PROJECT TITLE: GORMAN ZONE MAP: J13
DRB#: --- EPC#: --- WORK ORDER#: ---

**RE: Gorman Warehouse Addition
1330 12th Street NW
Request Permanent C.O. – Accepted
Engineers Stamp Date 2/11/15 (J13D100)
Certification Dated (1-15-16)**

Re: Gorman Industries, Warehouse Addition
1330 12th St., NW
Request for Certificate of Occupancy- Transportation Development
Engineer's/Architect's Stamp dated 11-26-14 (J13-D100)
Certification dated 1-13-16

Re: Gorman Industries, Warehouse Addition
1330 12th St., NW
Request for Certificate of Occupancy- Transportation Development
Engineer's/Architect's Stamp dated ~~12-1-14~~ (J13-D100)
Certification dated 1-13-16 *11-26-14*

TCL1

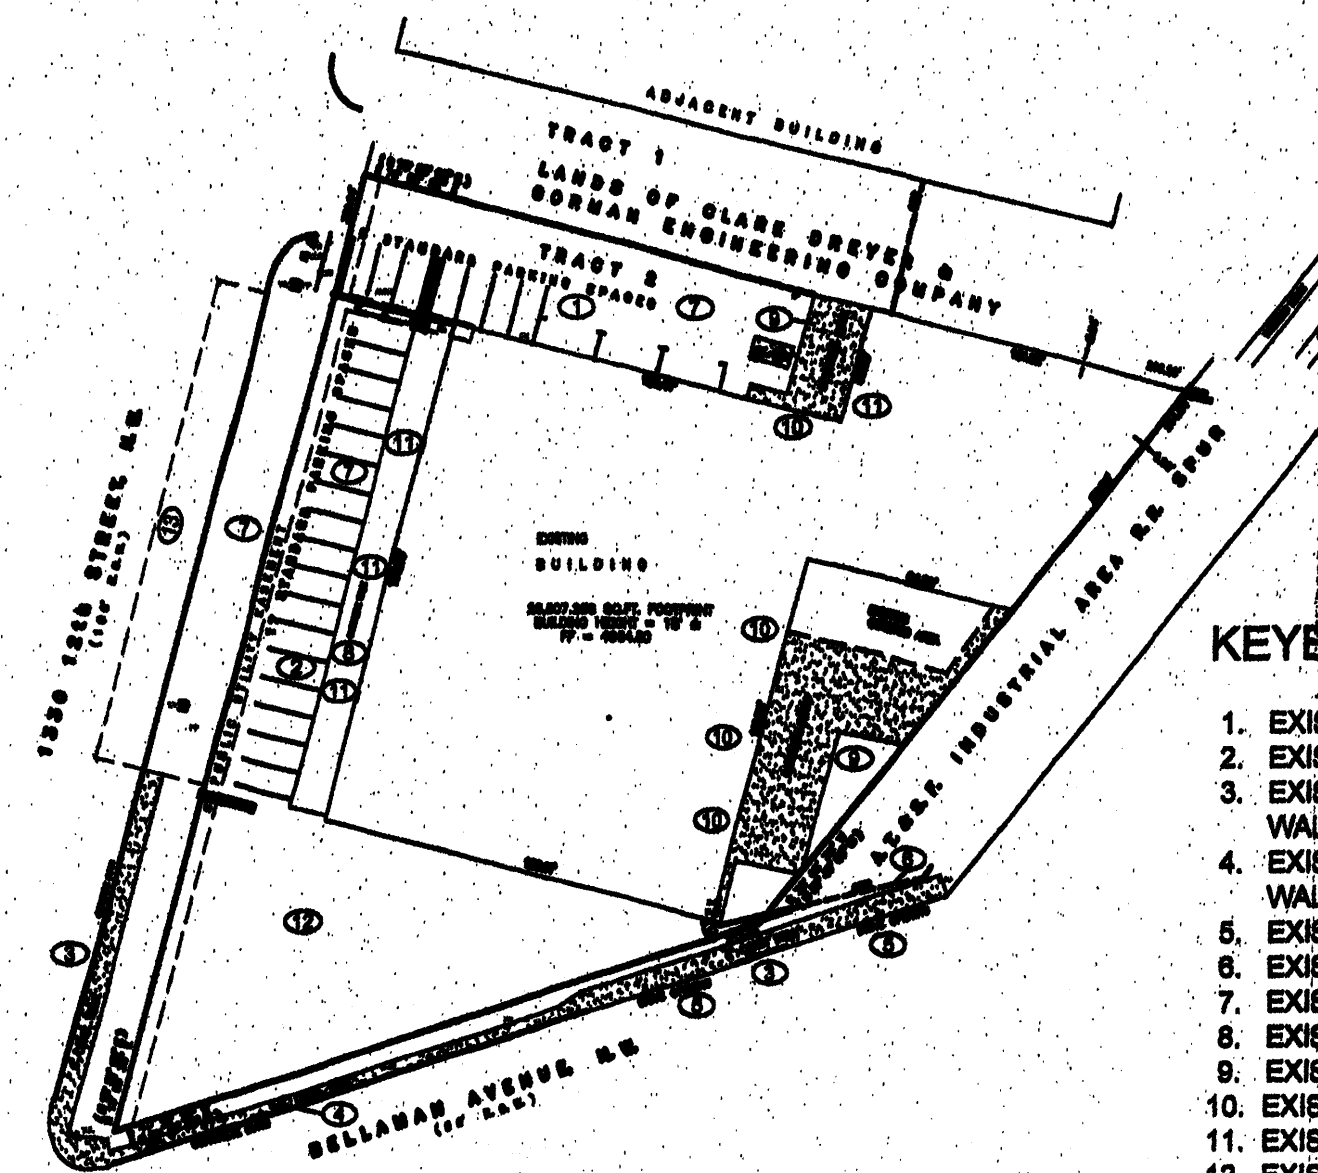
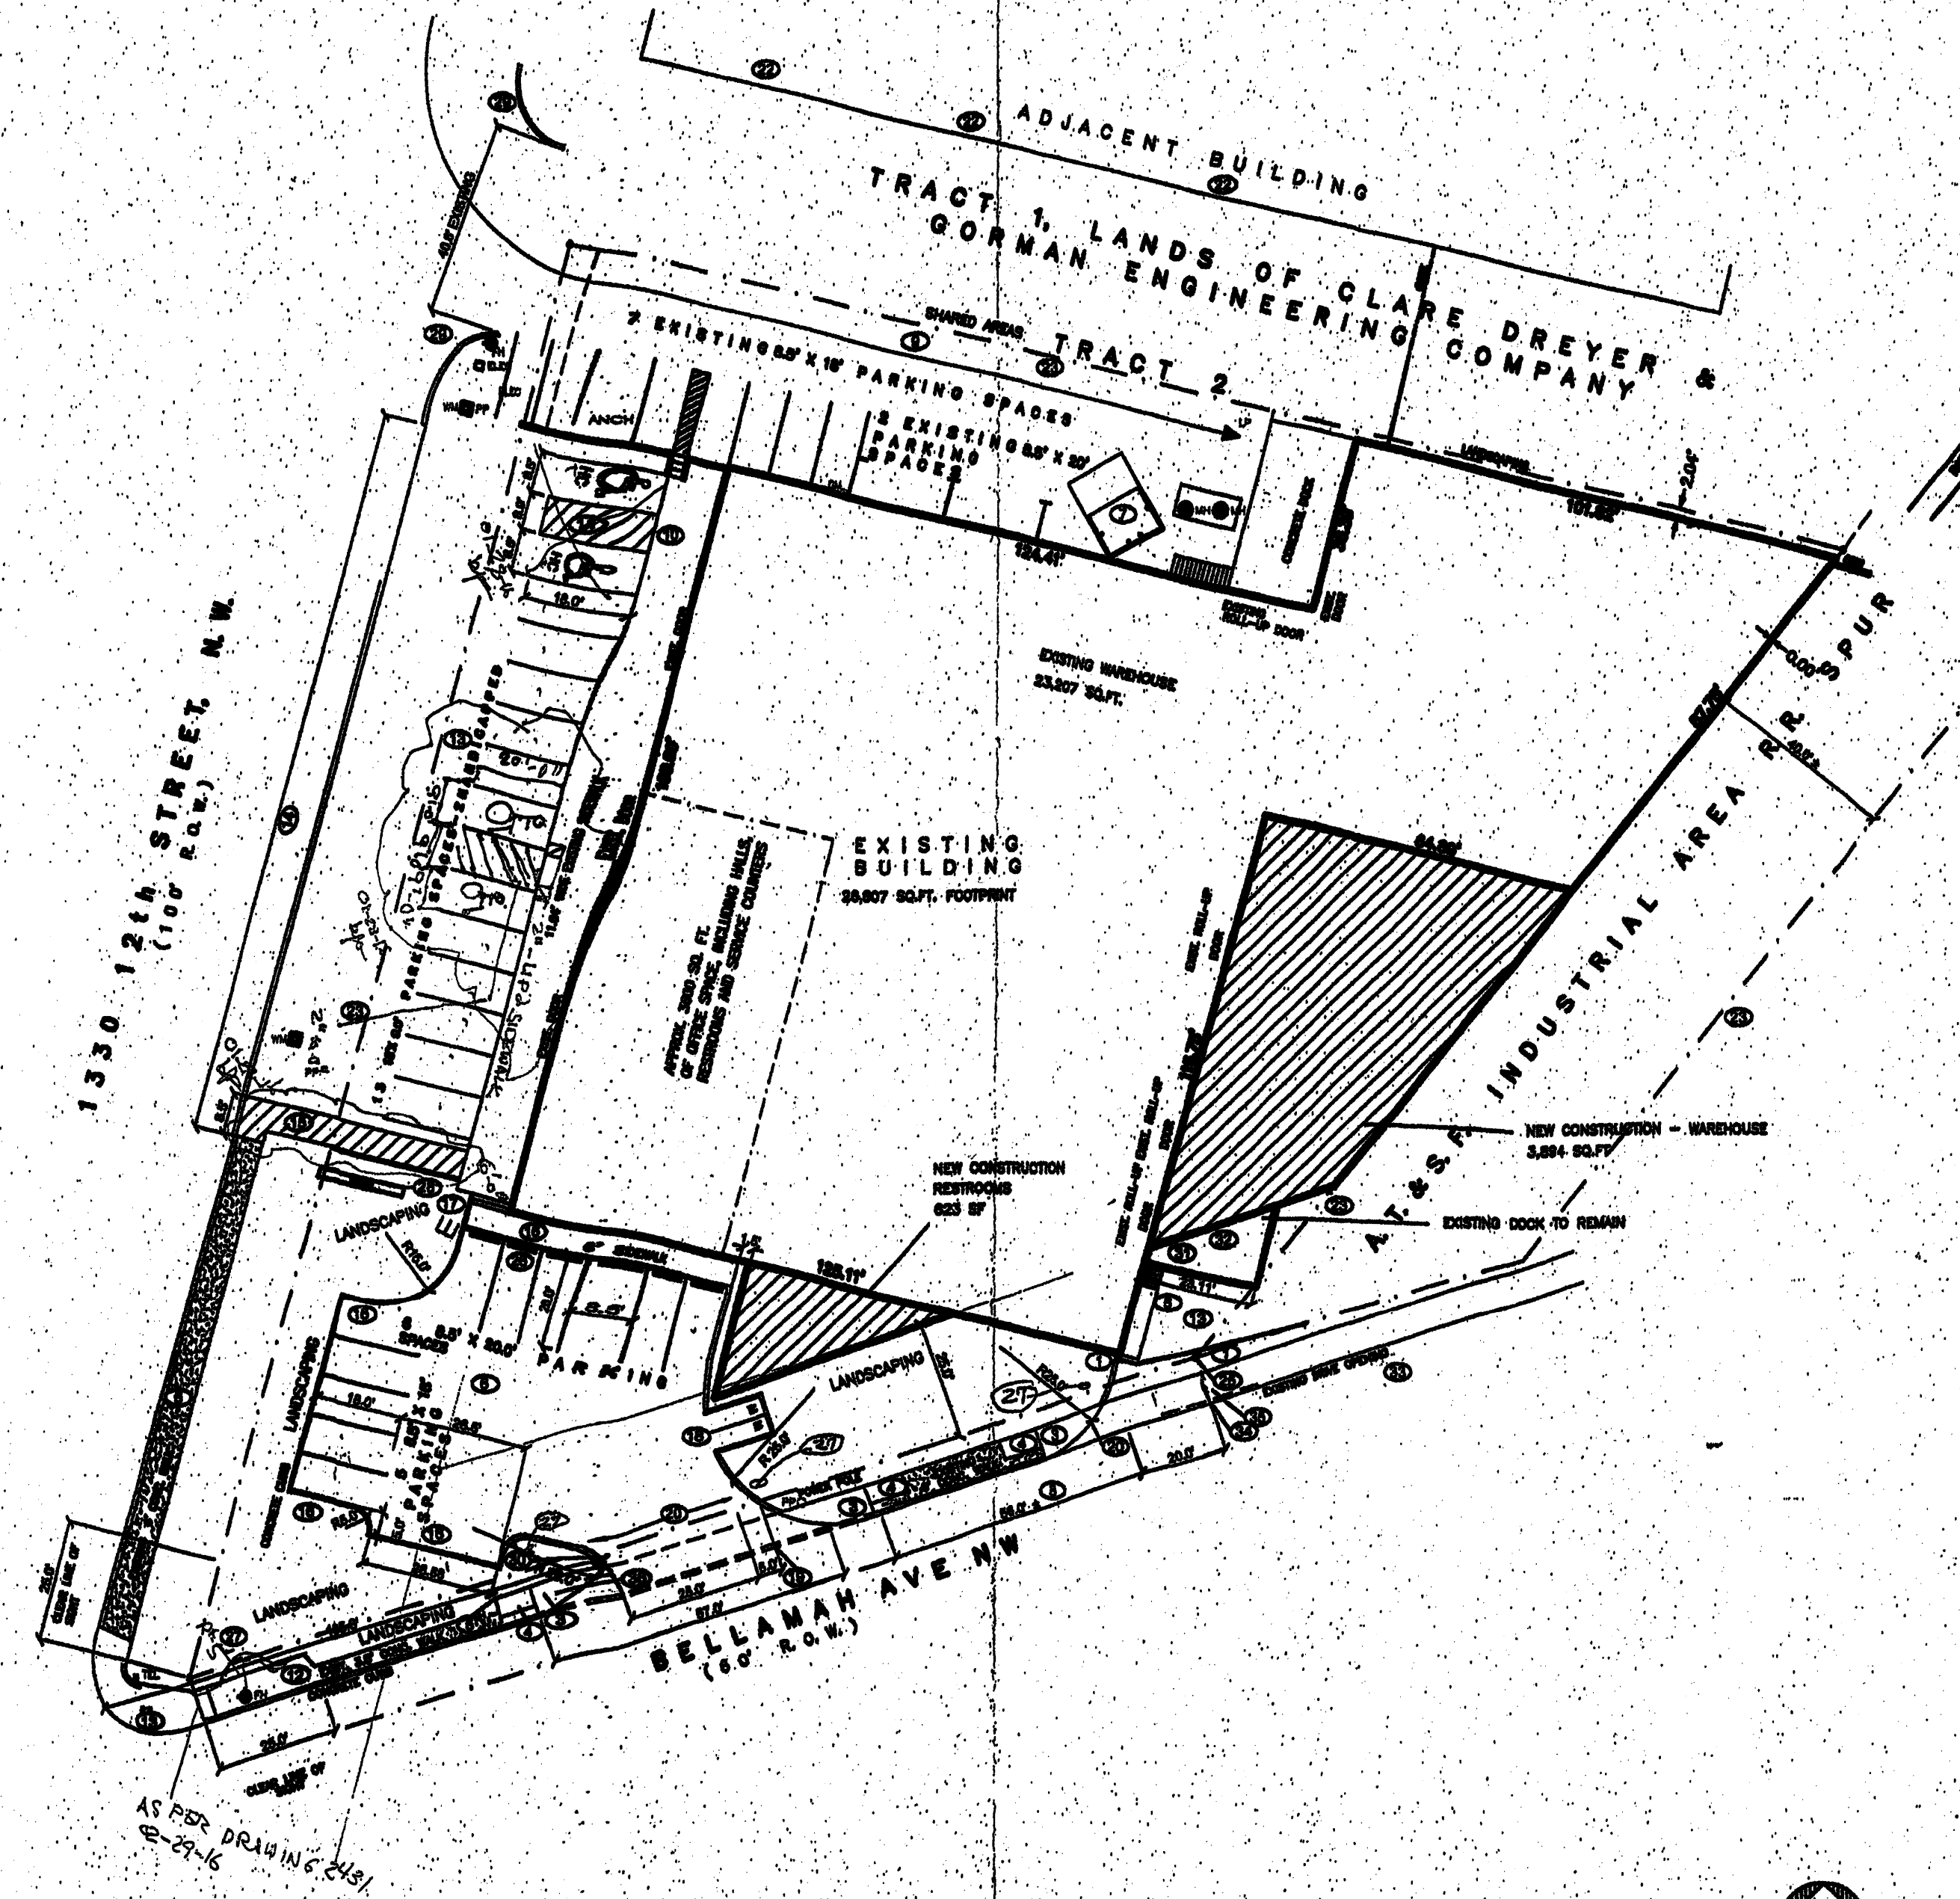
1. Keep a clear sight distance at the new access off of Bellamah Avenue, using the guidelines for the mini clear sight triangle on Page 23-74 of the DPM.
2. As per Note 15 on the site plan for the 6-foot wide ADA access from 12th Street, make sure that the ADA access route is built to be flush with the existing 11-foot sidewalk adjacent to the building.
3. Be sure to install the required handicapped signage for both van accessible handicapped spaces on the building as discussed using the signage that you sent in an e-mail dated 11-26-14.
4. Make note of the stamp "All wheelchair ramps located within public right-of-way must have truncated domes." on your approved TCL. Apply this to the new ramps that you are placing within public right-of-way.
